KIRKLEES METROPOLITAN COUNCIL INVESTMENT & REGENERATION SERVICE

DELEGATED DECISION TO DETERMINE APPLICATIONS FOR LISTED BUILDING CONSENT

Reference No:	2024/65/90506/W
Site Address:	6, Yew Tree, Yew Tree Lane, Slaithwaite, Huddersfield, HD7 5UD
Description:	Listed Building Consent for demolition of existing lean-to, erection of single storey rear extension, installation of 2no. new windows and alterations
Recommending Officer:	Laura Yeadon

DECISION – CONSENT REFUSED

Proposed rear/north west facing elevation (1:100)

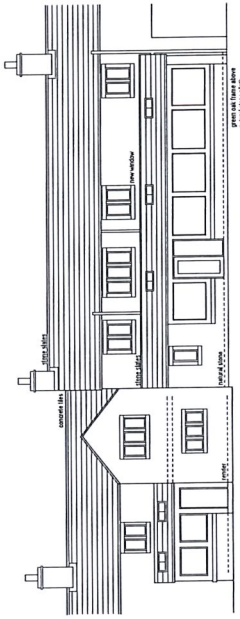
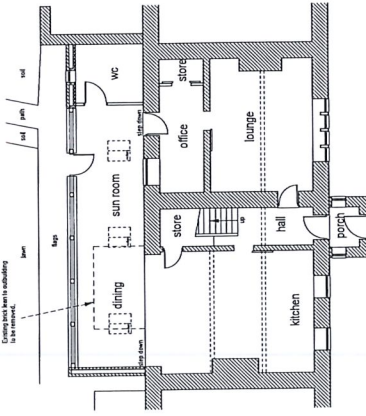
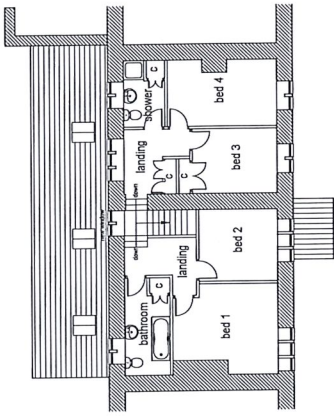
Whilst the design of the proposed extension is similar to that on No. 5, the proposed extension is significantly larger and as the north wall is constructed from stone, the impact of the proposed extension would be far more harmful. Although the use of natural stone is used at low level and for the proposed WC, with a stone slate roof, a long range of green oak framed windows is proposed that do not respect the character of this visible elevation, which is characterised by few openings and extensive coursed stone walling.

The Georgian Group have also made comments on the proposed works and state that there are significant concerns with the proposed works which involves the demolition and irreversible loss of a considerable amount of the historic ground floor external south wall and would also harm the evidential value of the building as a well preserved example of its type with good historical plan form and room volumes.

The comments go on to state that the proposed extension is furthermore massive and assertive and would considerably alter the appearance of the rear elevation, eroding the building's historic character and aesthetic value on the elevation which is publicly visible from Yew Tree Road.

It is therefore considered that the works would cause significant harm to the Listed Building resulting in an irreversible loss of historic fabric and harm to the buildings historic character and aesthetic value.

Taking all the above into consideration, it is considered that with particular regard to the extension, this would lead to less than substantial harm to the significance of the host Listed Building by introducing a substantial structure with extensive glazing whereby no public benefits have been demonstrated to outweigh the identified harm. In addition, the works would result in an irreversible loss of historic fabric with the removal of a large section of original walling leading to the erosion of the building's historic fabric and aesthetic value. Therefore, the proposal fails to comply with the statutory duties under Section 16(2) of the Planning (Listed Buildings and Conservation Areas) Act 1990, policies LP24 and LP35 of the Kirklees Local Plan and paragraphs 205, 206 and 208 of the National Planning Policy Framework

Proposed first floor layout (1:100)

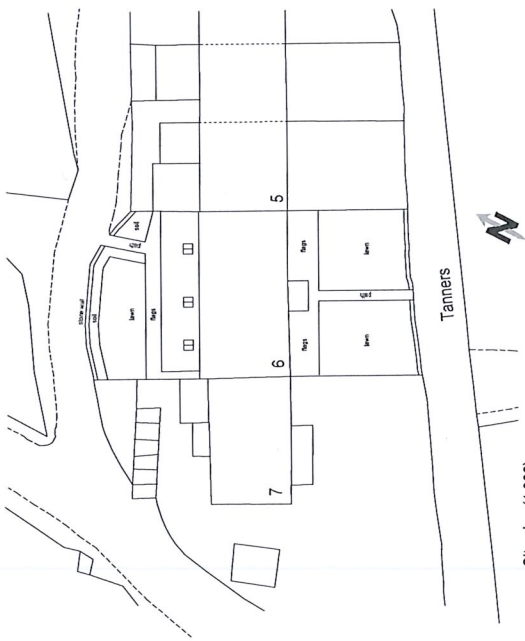
With regard to the pair of mullioned windows within the first floor of the building, there is no objection, subject to details being submitted for approval demonstrating that these are painted white, constructed from timber, slim double glazing with ashlar surrounds.
